From: ALAN ALLISON [REDACTED]
Sent: 02 December 2019 18:58
To: Andrew Wood <Andrew.Wood@arun.gov.uk>
Subject: email to Parish Council 25 November Minor Amendments Lanes End WA/7/19/RES

Comments on Option Unit 6

PJ DEVELOPMENTS LTD 2 Square Chambers 23 High Street Emsworth PO10 7AQ Tel: 0843 289 3430 Email: enquiries@pjdevelopmentsltd.com	
PROJECT: FORMER LANES END	
SITE PLAN OUTLINE PLANNING APPLICATION	
DATE: JANUARY 2019	DWG. NO 19-001 PL02
SCALE @ A1: 1:200	
REV: C

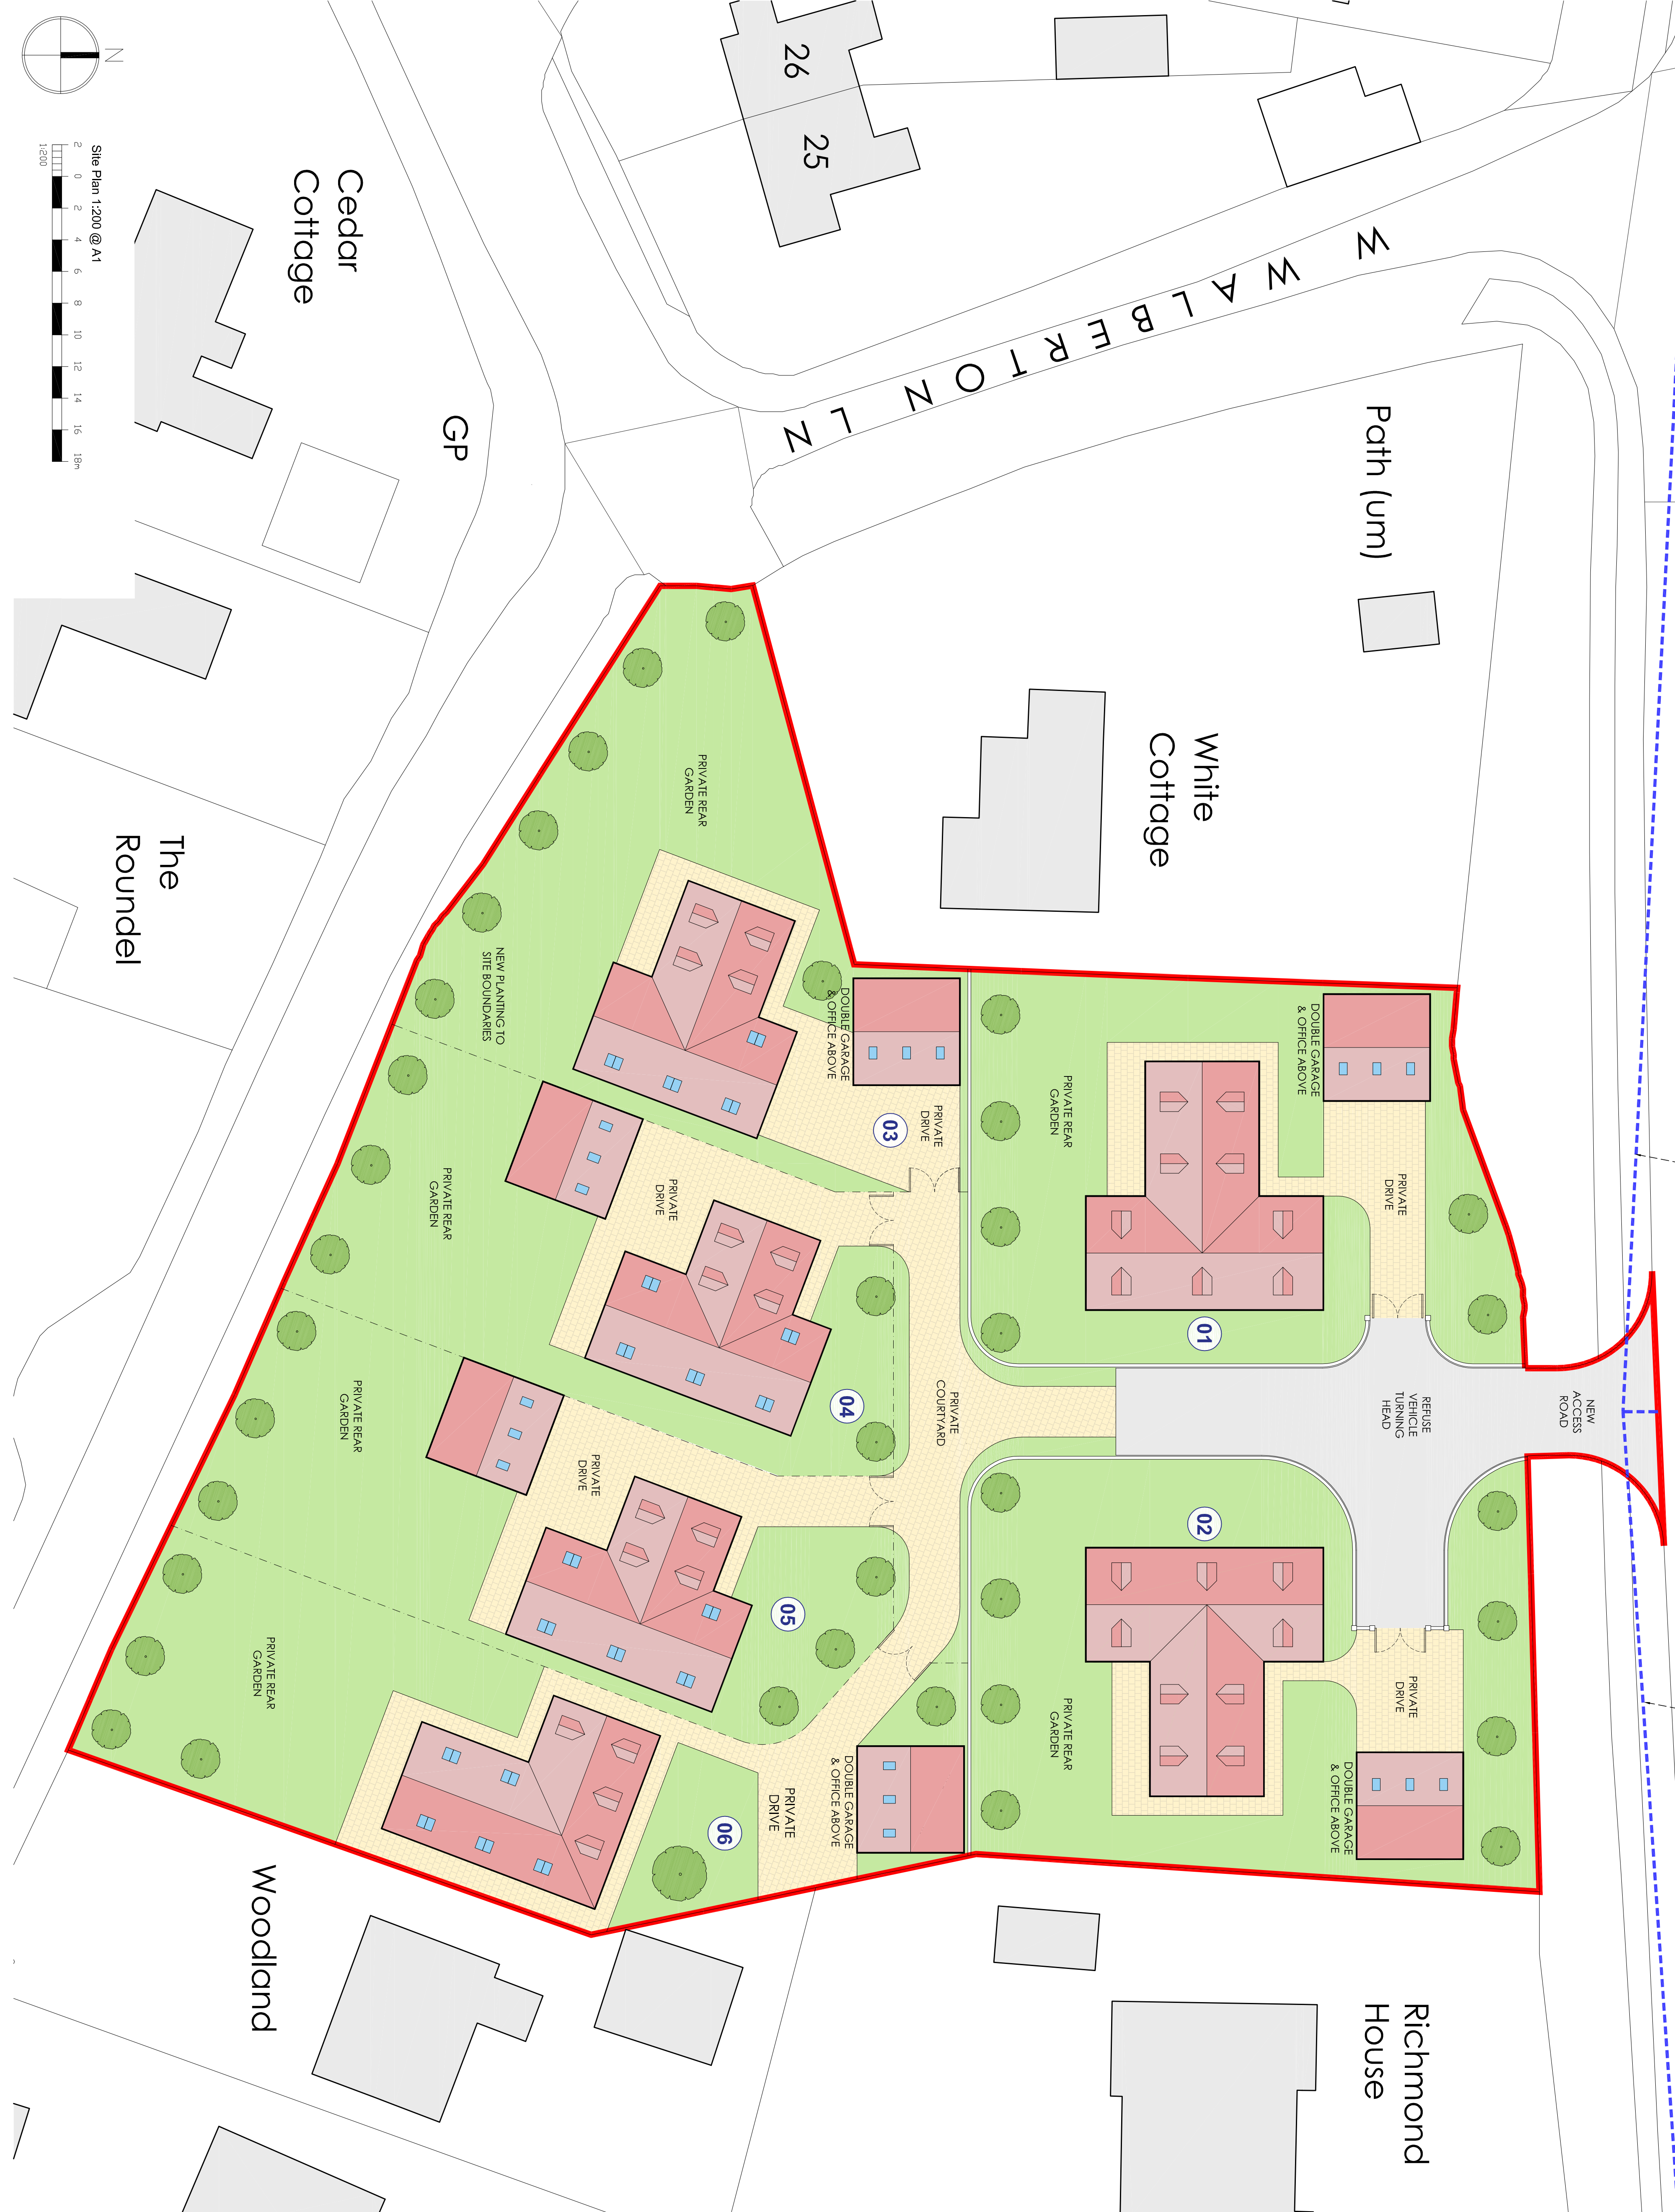
1. The view from Woodland would be badly affected. The existing Lanes End house is c40 metres from the boundary, but the unit 6 is less than 5 metres.
2. The size and closeness of unit 6 would mean a major loss of natural light in Woodland, our house, and would cast a large shadow over Woodland, its patio, conservatory and gardens on sunny afternoons
3. Most unit 6 windows will probably be on the wall facing Woodland, and more than on previous plans. These windows should be obscured glass and non-opening, to protect privacy of Woodland occupants.
4. Surface water run-off from the building will have an immediate effect on Woodland property.

1. The moving of unit 6 south from the outline plan position to the now proposed position shortens the garden length, and will badly affect its use as there are 2 trees with TPOs at the southern end of the plot.

2 Being so close to Woodland house would mean a major loss of privacy in unit 6.

It would be better for everyone to move unit 6 further North and turned slightly as shown on attached drawing A&V dated 1.12.2019 – nearer the position in the approved outline Block Plan. This removes most overlooking and privacy loss in both directions.
